Rezoning Transportation Analysis
Petition Number: Insert Zoning Petition #2020-184
General Location Identifier: 06703101

Revision Log:	Date	Description
	01-21-2021	First Review (KP)
	02-10-2021	Second Review (KP)
	03-24-2021	Third Review (KP)

The site is located on the northwest corner of the Freedom Drive and Morehead Street intersection, of which both streets are State-maintained major thoroughfares. As this petition is focused on amending a site plan, this site will not necessitate any transportation improvements. There are existing bicycle and pedestrian infrastructure that will be utilized for this site, constructed as a part of the 2010 West Morehead Streetscape Project CECAP Project. CDOT has no outstanding issues with this petition.

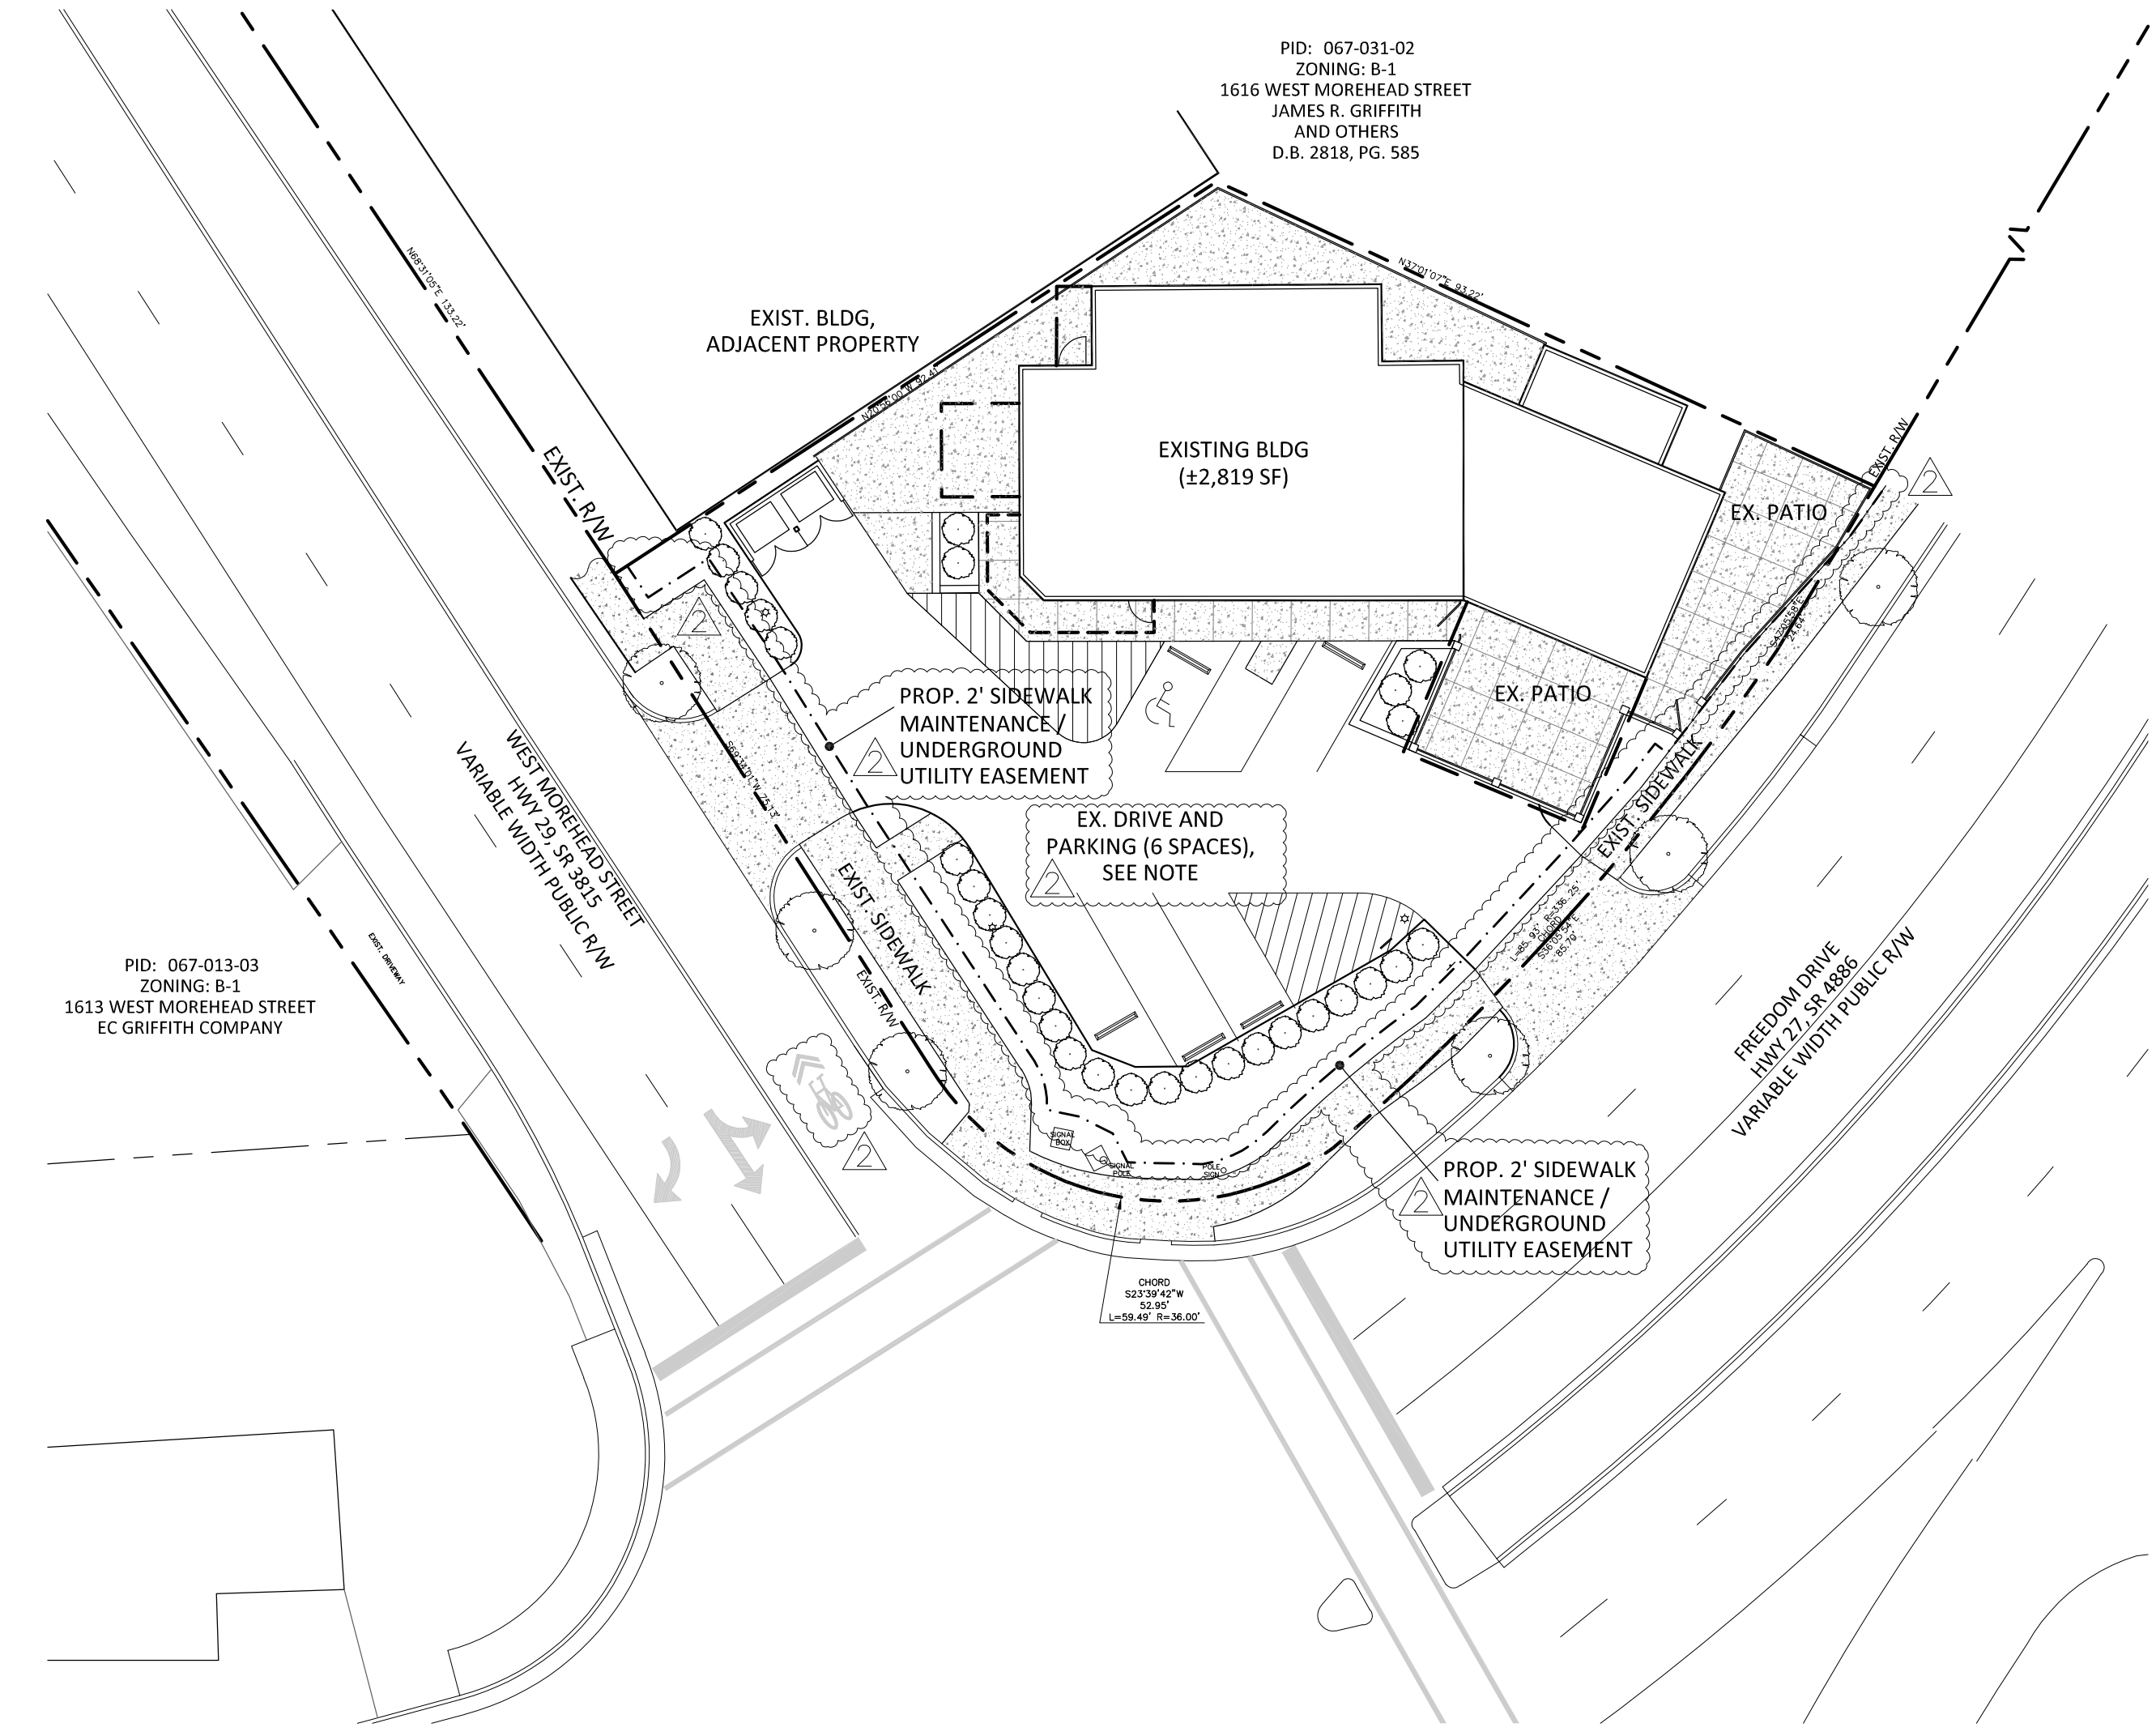
- ~~Revise the site plan by adding a sidewalk utility easement 2-foot behind the sidewalk along the site's Morehead Street and Freedom Drive frontage.~~

~~**Update to Comment from 02-08-2021 Site Plan:** Please change the language on Transportation Note 2 to "The petitioner will provide an easement to CDOT and NCDOT, as generally depicted on the site plan, for a 2-foot wide area behind and coterminous with the existing sidewalk along both West Morehead Street and Freedom Drive for sidewalk maintenance and underground utilities." Additionally, please clearly show and label the SUE on the site plan.~~

- ~~Revise the site plan by correcting the West Morehead Street pavement markings.~~

~~**Update to Comment from 02-08-2021 Site Plan:** Please include all pavement markings.~~

3. ~~A site plan note(s) specifying dedication and fee simple conveyance of all rights-of-way to NCDOT before the site's first building certificate of occupancy is issued is needed. CDOT requests rights-of-way set at 2' behind back of sidewalk where feasible.~~

The Petitioner will provide an easement to either the City of Charlotte or to NCDOT, whichever has jurisdiction, for a 2' wide area behind and directly coterminous with the existing sidewalk along both West Morehead Street and Freedom Drive for sidewalk maintenance and for underground utilities ~~except where such easement would encroach upon the existing development on the site.~~
